PLANNING CONSULTATION RESPONSE

Application No	2025/1062
Proposal	Demolition of existing domestic garage and formation of new driveway/parking, and outline permission for the erection of 4 houses within the residential garden (including access and layout details).
Address	Land adjacent to 1A West Street, Worsbrough Bridge, Barnsley, S70 5PG
Date of Consultation Reply	03/08/2026
Consultee	Katie Lawrence, Planning Ecologist

SITE PLAN
SCALE 1:250

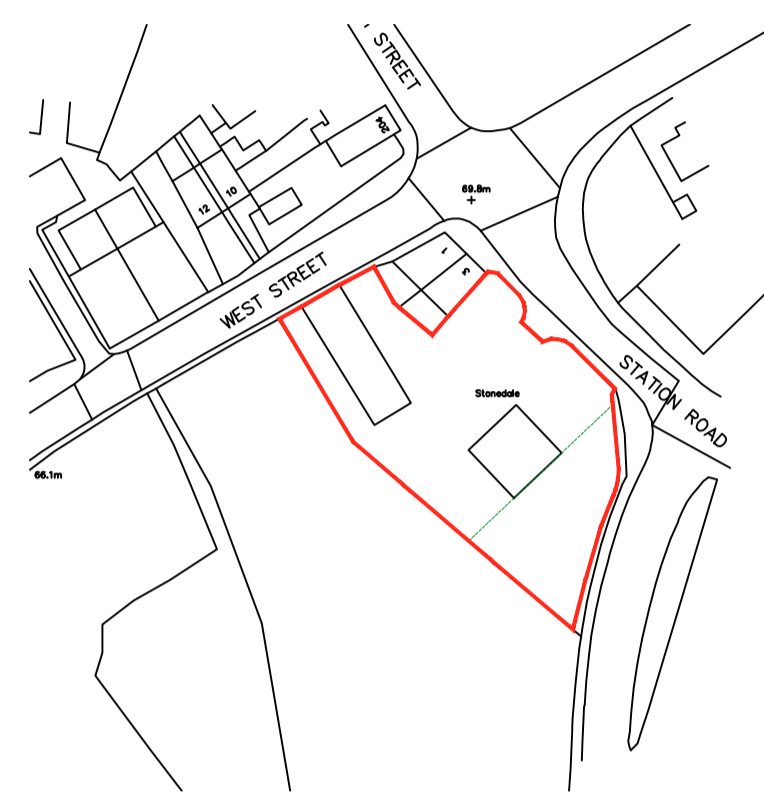
The site plans indicate that each of the four proposed dwellings will have relatively small garden areas, with a larger area of modified grassland situated outside the gardens, but within the red line boundary. Could the applicant please confirm whether the modified grassland will lie outside the boundaries of the residential curtilages? If this area is to remain outside the curtilages, clarification is required regarding its long-term management arrangements. Specifically:

- Who will be responsible for managing and maintaining the grassland for the required 30-year period?
- What measures will be put in place to ensure residents do not encroach into, alter, or domesticate this grassland area?

If the modified grassland falls within the curtilage of the dwellings, then it should be mapped as vegetated/unvegetated garden, as per metric guidance.

When referring to the proposed development plan included within appendix 3 of the BNG report this indicates that the area to the south-east of the proposed dwellings will be divided up into private gardens, with fencing shown on the plan marking the curtilages of the properties (see screenshot of proposed development plan below).

Appendix 2: Post-Development Habitat Plan

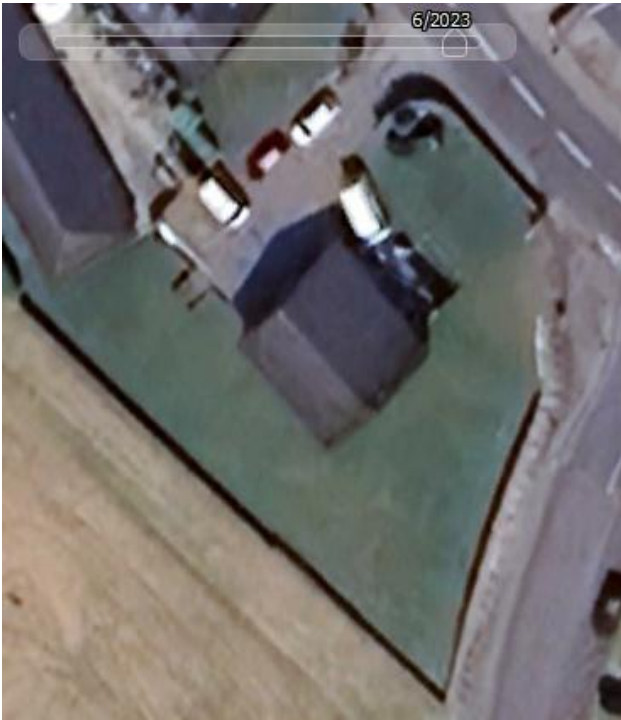
The post development plan included within appendix 2 of the report still shows this area as modified grassland (see screenshot below). As discussed above the applicant should confirm if this area will be private garden or an area of public open space and the BNG calculation amended, where necessary.

If this affects the change in biodiversity value on site and a 10% net gain is not achieved, the applicant may wish to consider the planting of native trees in areas where public open space is proposed, as suggested in the previous response. A small number of small native trees would not likely be deemed as significant habitat enhancement and a Habitat Management and Monitoring Plan condition is unlikely to be required. In such cases, a condition for a five-year Biodiversity Enhancement Management Plan is likely to be more appropriate.
